Our Ref: AB/77/17/PL

**Town & Country Planning Act 1990 (as amended)
Town and Country Planning (Development Management Procedure) (England) Order 2015
Application for Full Planning Permission**

Development	Demolition of existing dwelling & buildings. Erection of a block of 45 sheltered apartments for the elderly (comprising 21 x one bedroom apartments and 24 x two bedroom apartments age restricted to 60 years and over); with associated access, electric buggy/cycle store, refuse bin store & 34 parking spaces.
Location	Blastreat Limited and Adjoining Greenhurst Fitzalan Road Arundel

Location Plan
Scale 1:1250

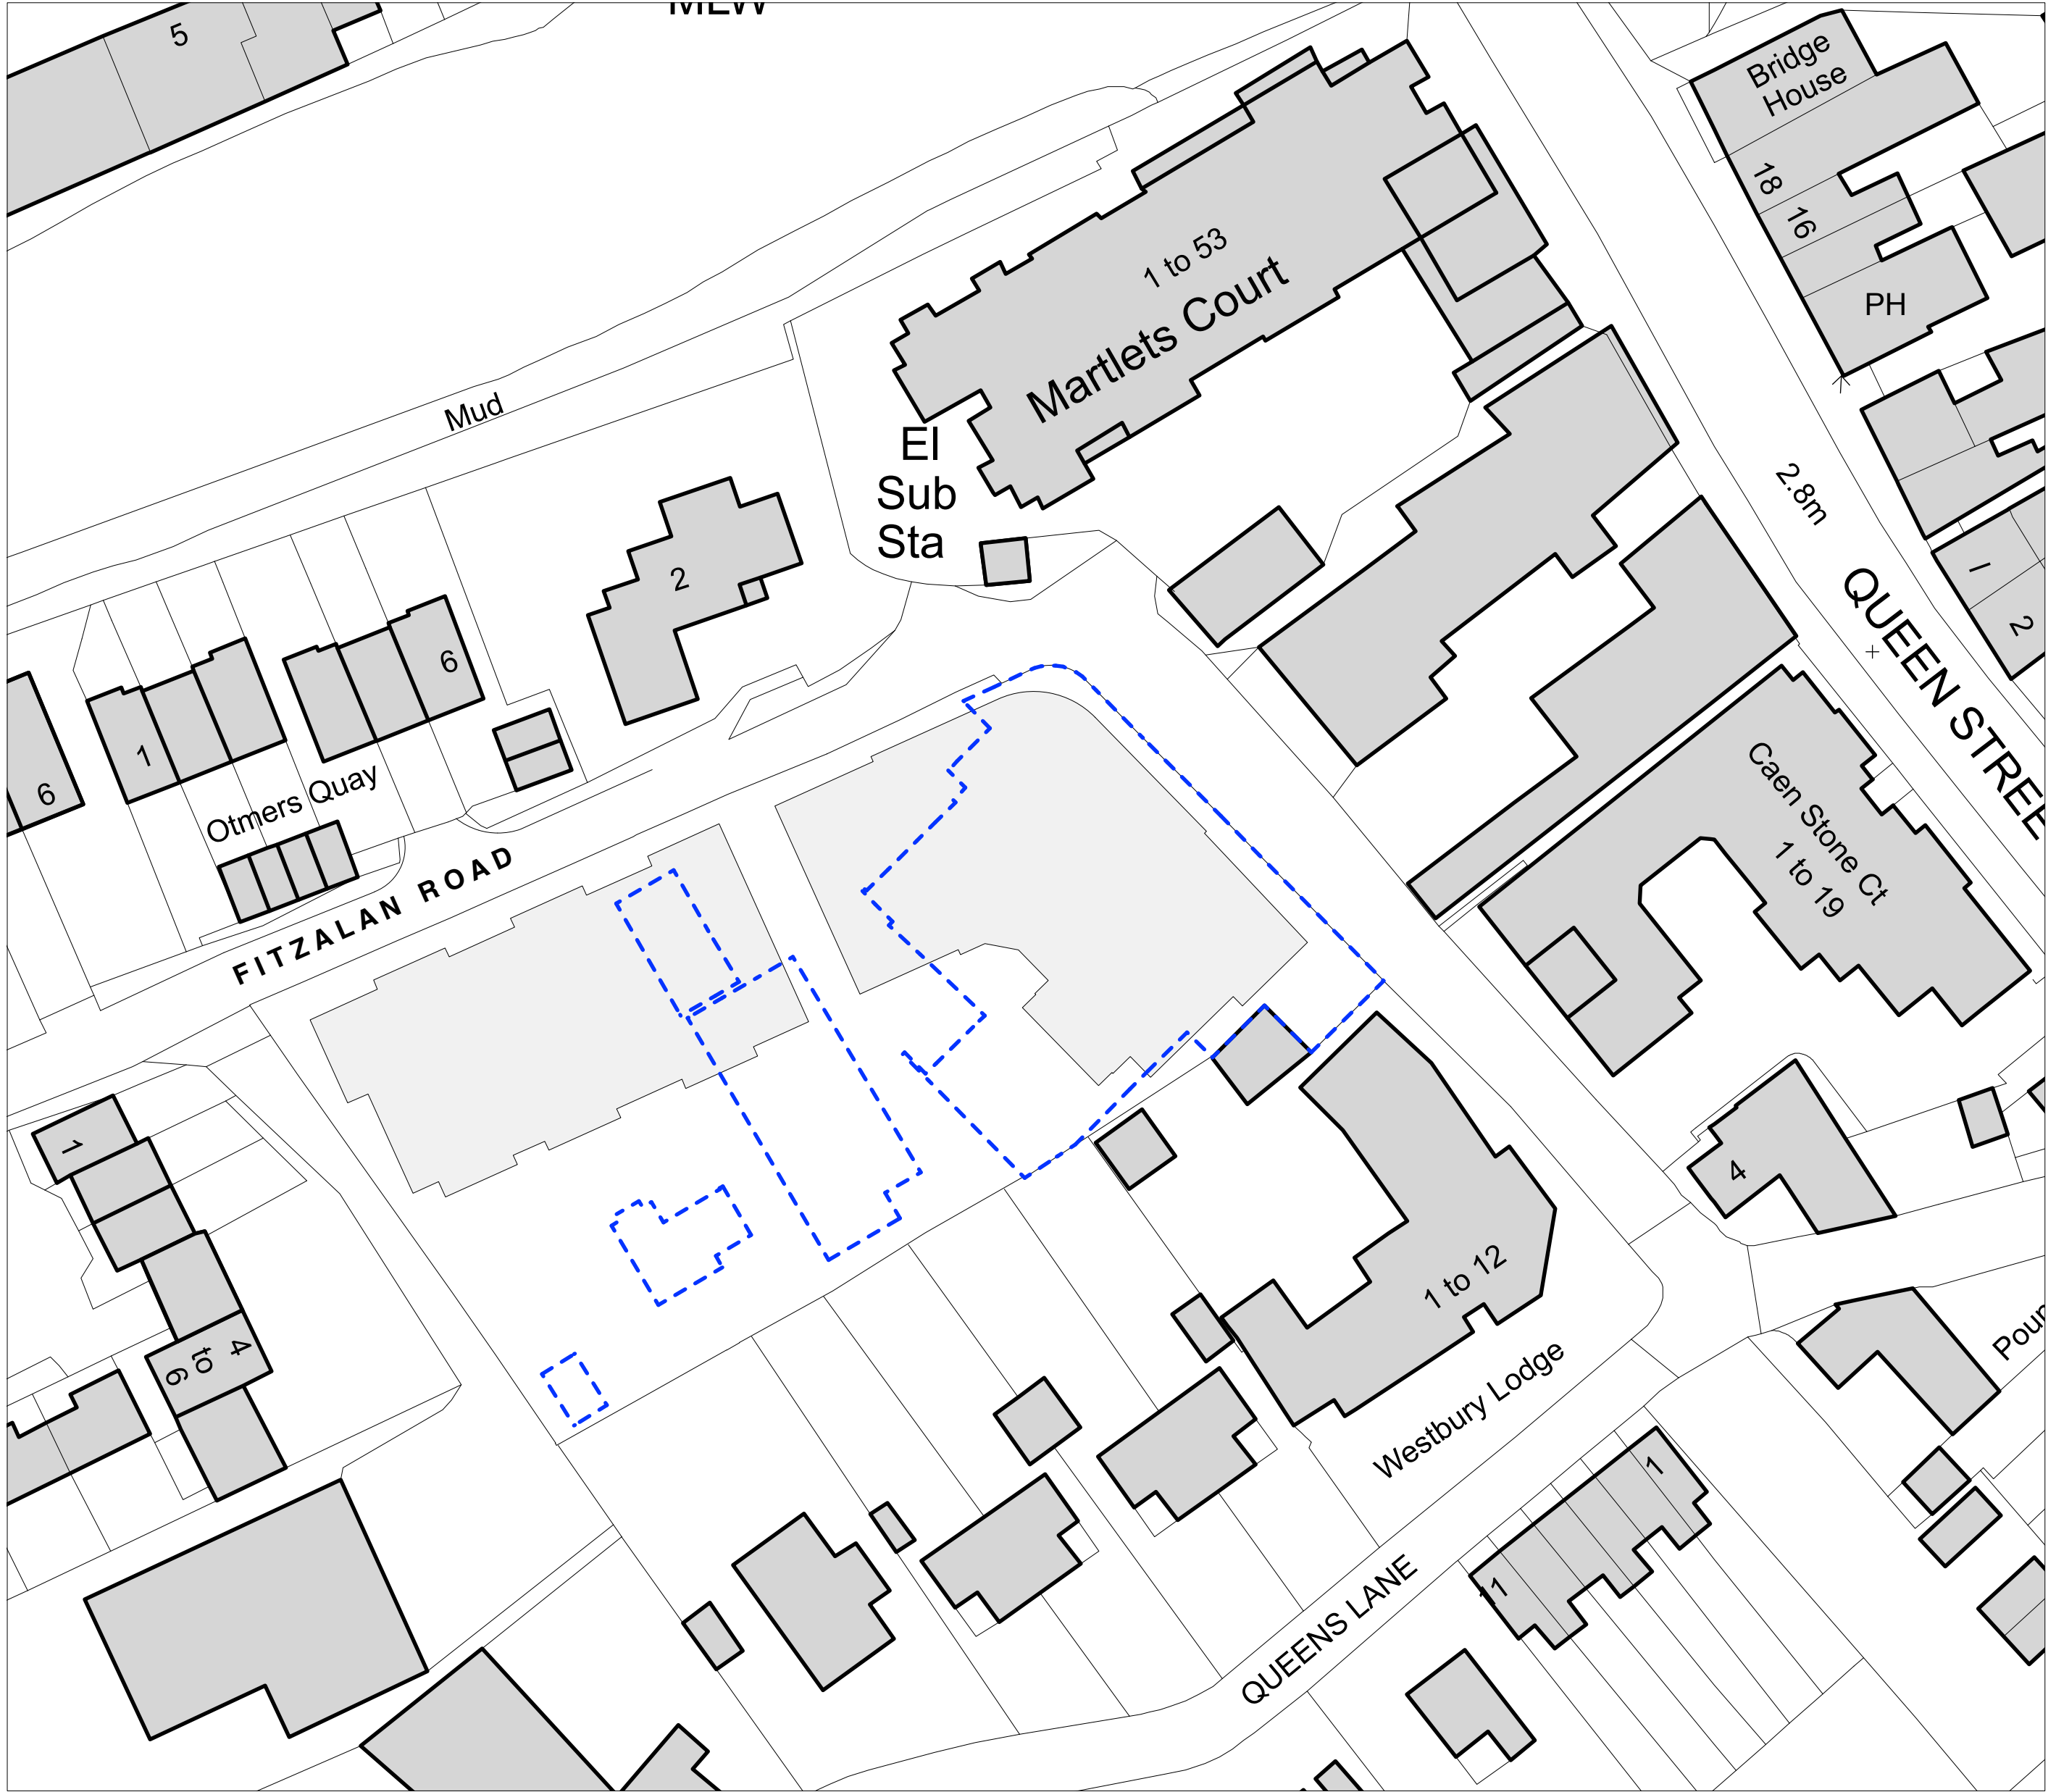
Block Plan - Amend

Please submit 1 electronic or 3 paper copies of an amended block/site plan at a scale of 1:500 or 1:200. Please remove the word 'draft' from the plan title & add the dimensions to boundaries shown on the plan. Further details of what must be included on the plan can be found in the National Validation Requirements.
